RE: An Coimisiún Pleanála - Case reference: PL10.322154. Planning Authority Case Reference: 2560003. Third Party response to letter received from An Coimisiún Pleanála in respect of a First Party appeal lodged in respect of the decision of Kilkenny County Council to refuse planning permission, under planning application Reg. Ref. 2560003 for ten year planning permission at a site situated in the townlands of Acragar, Ballyconra, Ballycuddihy, Ballyroe, Ballyroe (Grace), Ballyroe (Maher), Baunaniska, Boherkyle, Briskalagh, Brittas, Clone, Coolnapisha, Curraghduff, Freshford, Freshford Lots, Graigueswood, Grange, Huntstown, Kilmanagh, Knockeenglass, Knockown, Moatpark, Monabrika, Monavadaroe, Moneenaun, Oldtown, Oldtownhill, Parksgrove, Picketstown, Rathealy, Sart, Sweethill, Tobernapeastia, Tullaroan, Upperwood Demesne, Co. Kilkenny. The development will consist of the provision of the following: i. 7 no. wind turbines with an overall turbine tip height of 185 metres; a rotor blade diameter of 163 metres; and hub height of 103.5 metres, and associated foundations and hard standing areas; ii. A permanent 38kV substation compound (control building with welfare facilities, all associat

Figure 1 Cumulative Predicted Noise Contours

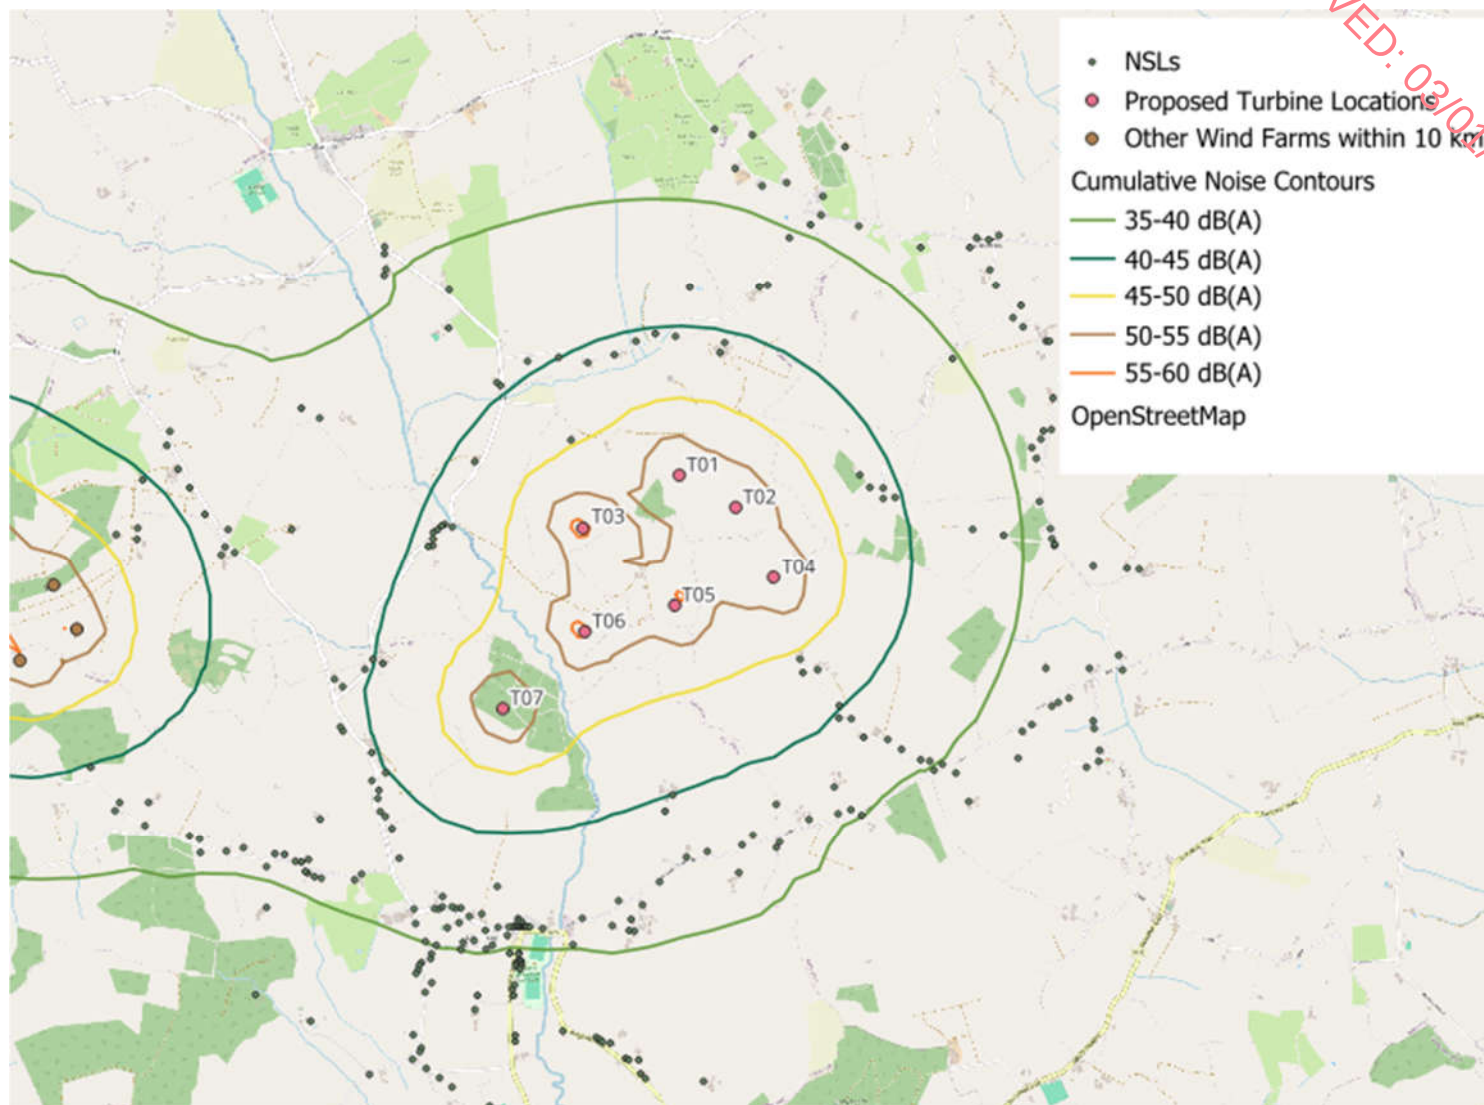
4. It is acknowledged that you have submitted a map of the study area which shows the predicted cumulative noise level contours at 9m/s wind speed (i.e. Appendix A of Appendix 3 of the First Party Appeal prepared by AWN Consulting) and all NSLs included within Appendix 12-7 (Predicted Cumulative Noise Levels) appear to have now been identified. From a review of the study area map,

it is noted that NSL 270 & 275 are located within the 40dB(A) contour associated with the Foyle Wind Farm. However, a predicted noise level of 35.9dB(A) and 35.3dB(A) has been indicated at these NSLs respectively at 9m/s within Appendix 12-7 of the EIAR. You are therefore requested to clarify these apparent discrepancies.
